## Appeal Decision

**Appeal Ref: APP/T2350/W/19/3239000**

**Three Millstones Inn, Waddington Road, West Bradford BB7 4SX**

- The appeal is made under section 78 of the Town and Country Planning Act 1990 against a refusal to grant planning permission.
  - The appeal is made by Mr Matthew Frost against the decision of Ribble Valley Borough Council.
  - The application Ref 3/2019/0554, dated 14 June 2019, was refused by notice dated 27 September 2019.
  - The development proposed is new single storey building at the rear of the public house to create an additional guest bedroom.
-

PROPOSED PLANS &
ELEVATIONS

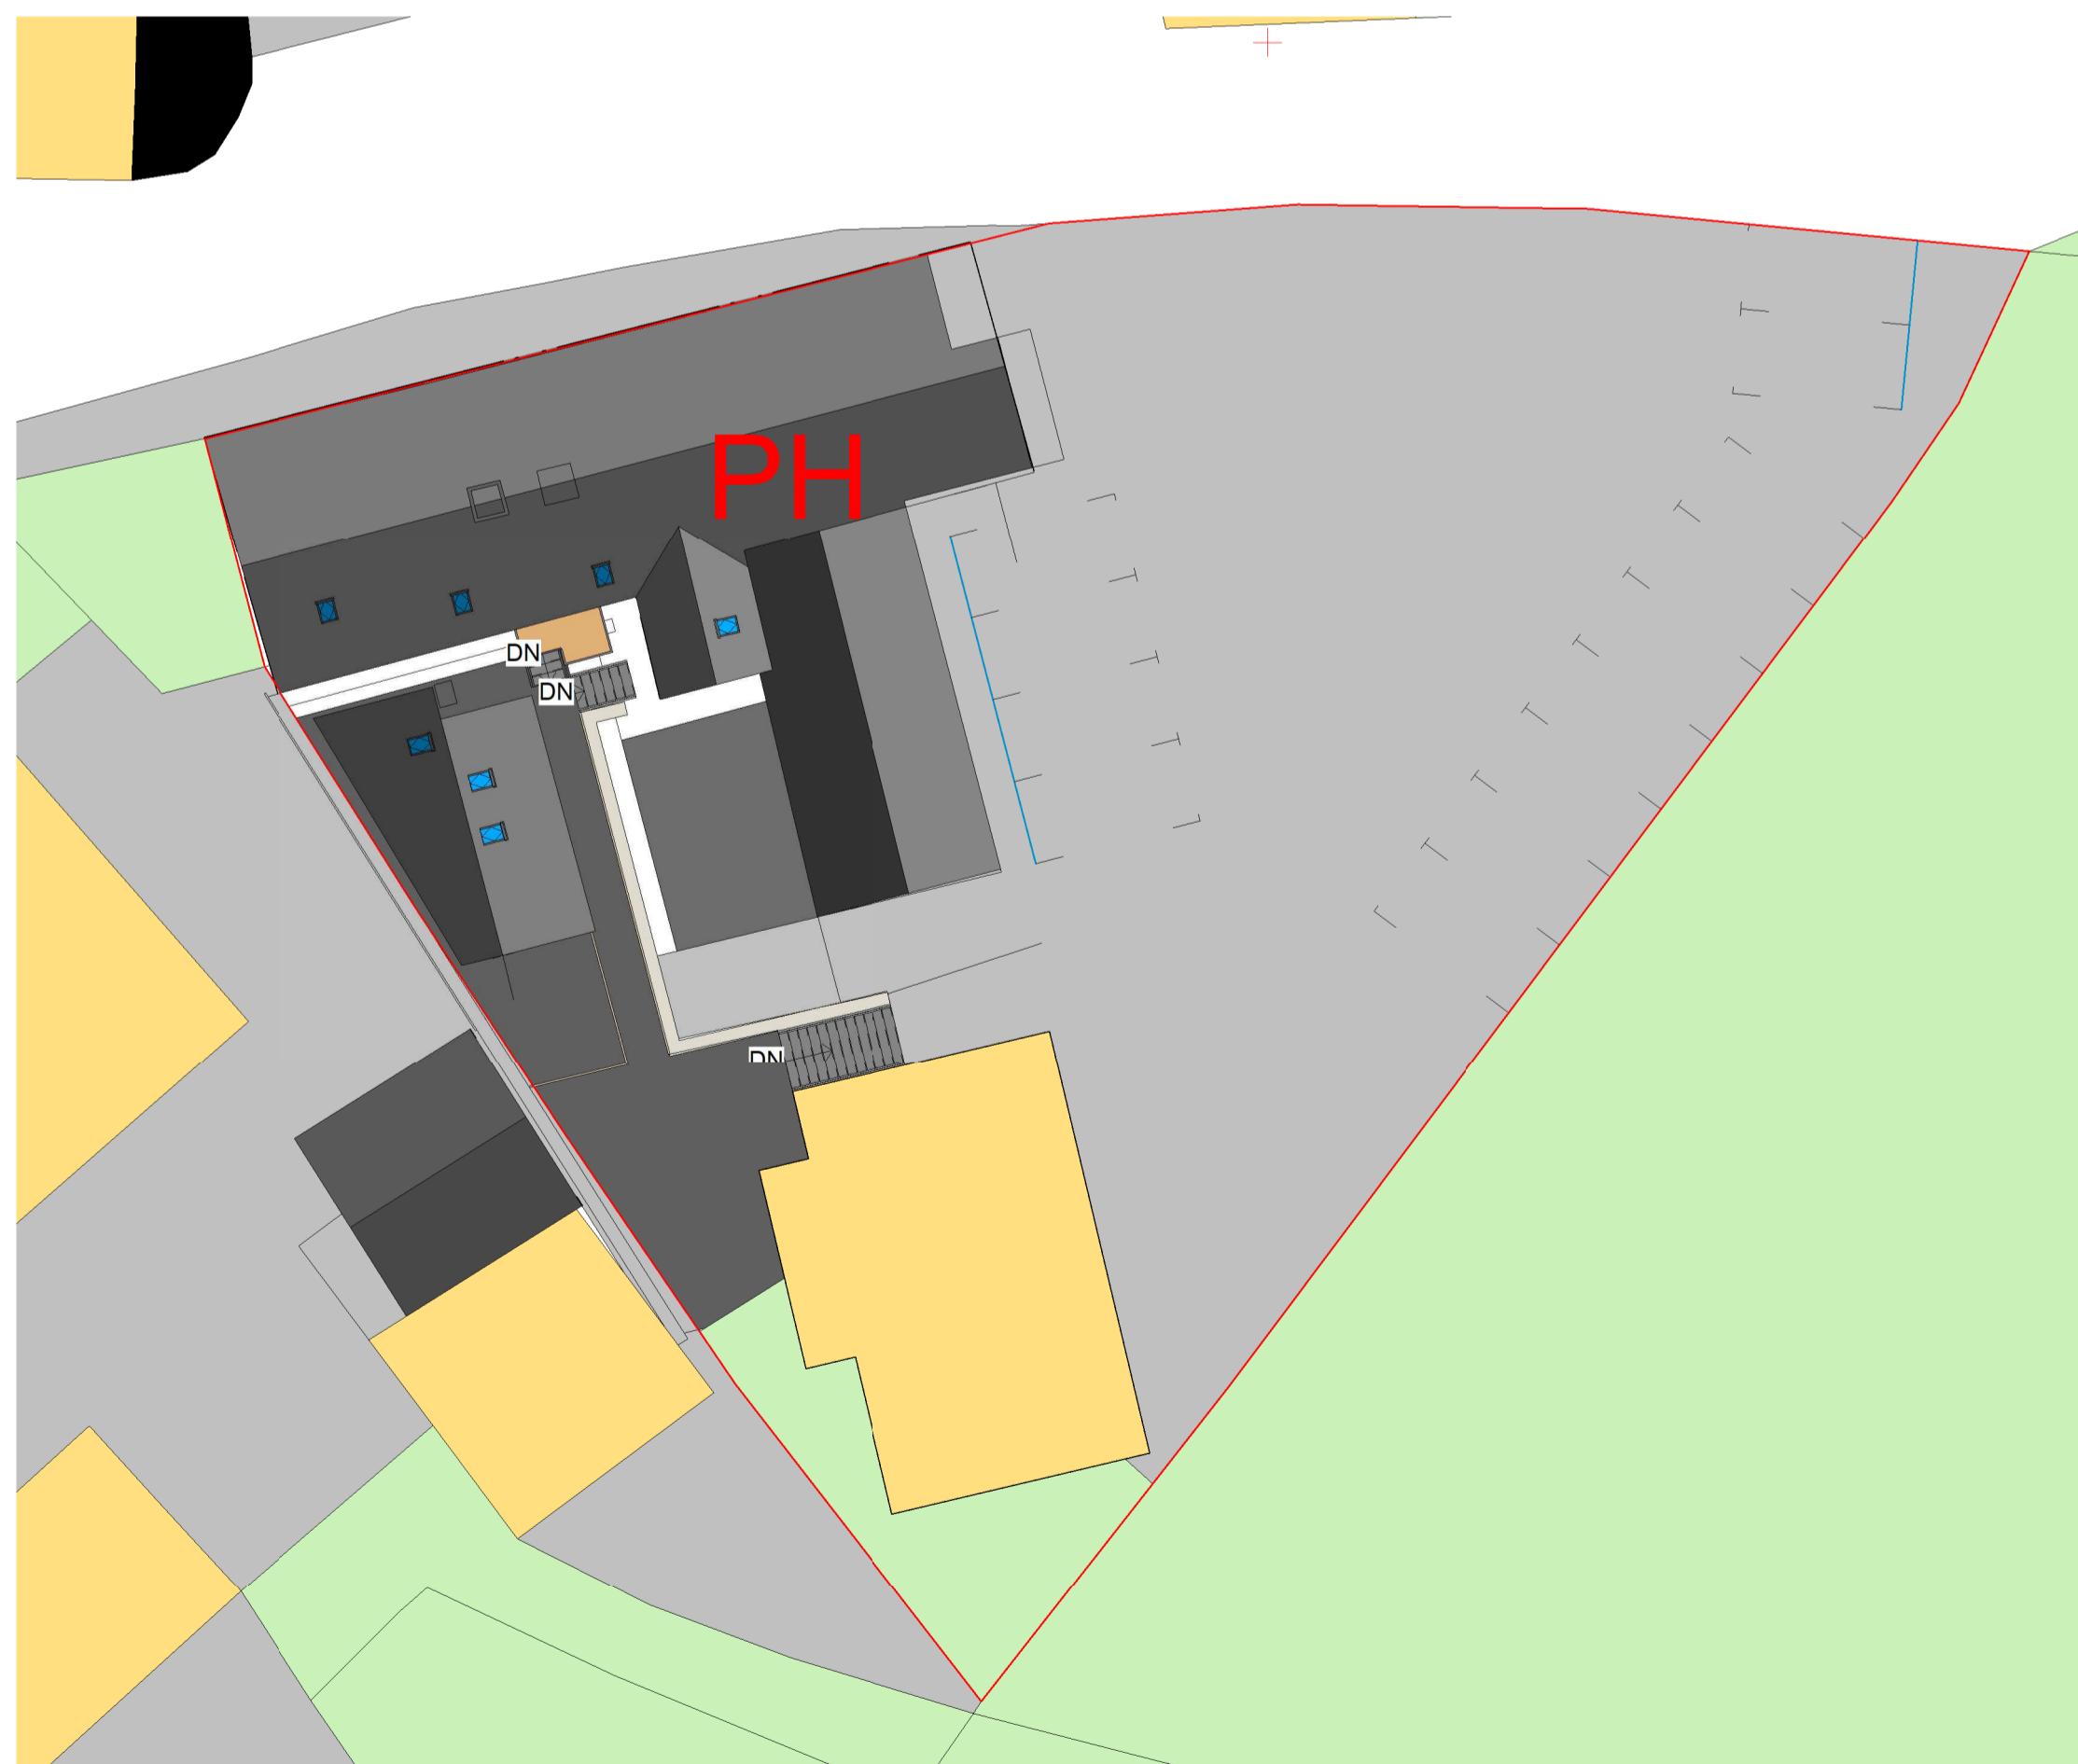
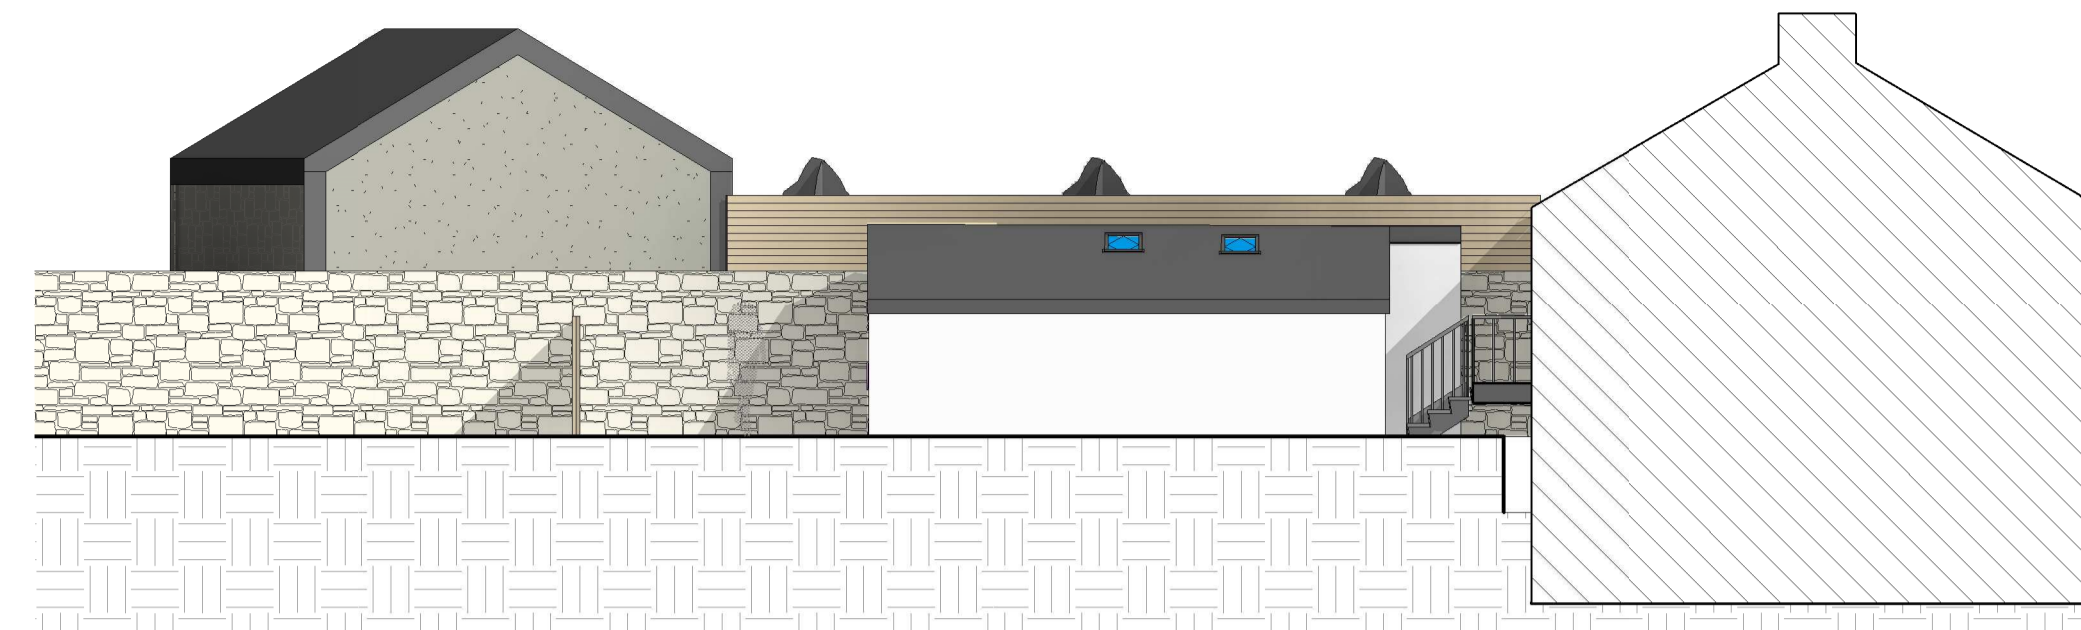
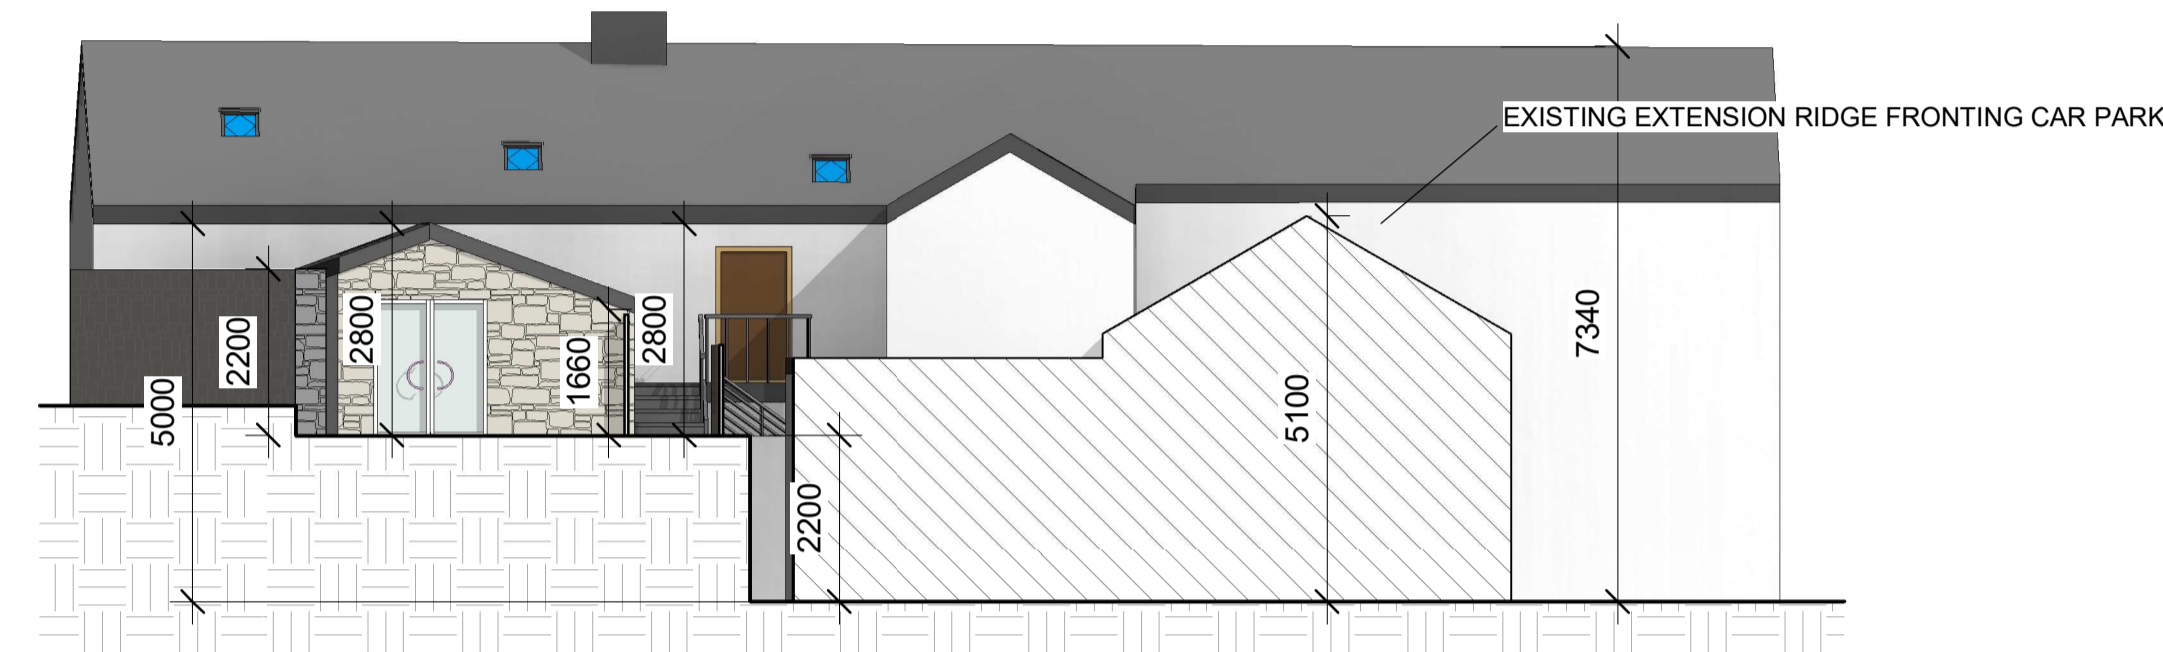
8. In contrast, as a result of its very shallow mono-pitched roof, which would slope upwards away from the rear of the original public house building for some significant depth, the proposed building would appear as a discordant feature, which would not reflect the appearance or the roof form or gradient of the listed building, or those sympathetically designed existing extensions, which either have gable-ends, or mono-pitched roofs sloping downwards away from the building. Furthermore, whilst lower than the listed building's roof ridge, the proposed building's eaves at their highest point would be higher than those of the adjacent part of the original building. As a result, it would not maintain a sense of subservience to the main listed building, and would appear as an unduly dominant feature which would detract from its setting.

10. In contrast, the elevations of the proposed building would be entirely timber clad, and its rear elevation would be fully glazed. It would also be located very close to the rear of the listed building. It would therefore be closely surrounded by, and viewed in the immediate context of, the whitewashed public house, its stone and whitewashed rear extensions, and the adjacent stone boundary wall. In that context, the exclusive use of timber along the building's expansive side elevation, on its own and together with the further expanse of timber fencing proposed beyond it and around its patio area, and the use of full height glazing to its rear elevation, would appear discordant, and would fail to maintain a sense of connection or continuity between the proposed building and the extended listed building. The use of the materials as proposed would therefore further contribute to the harm arising to the setting of the listed building.

13. However, for the reasons given, I consider that the proposed building would appear as an unduly dominant and discordant feature, which would not be sympathetic to the character or appearance of the listed building, and would cause harm to its setting as a result.
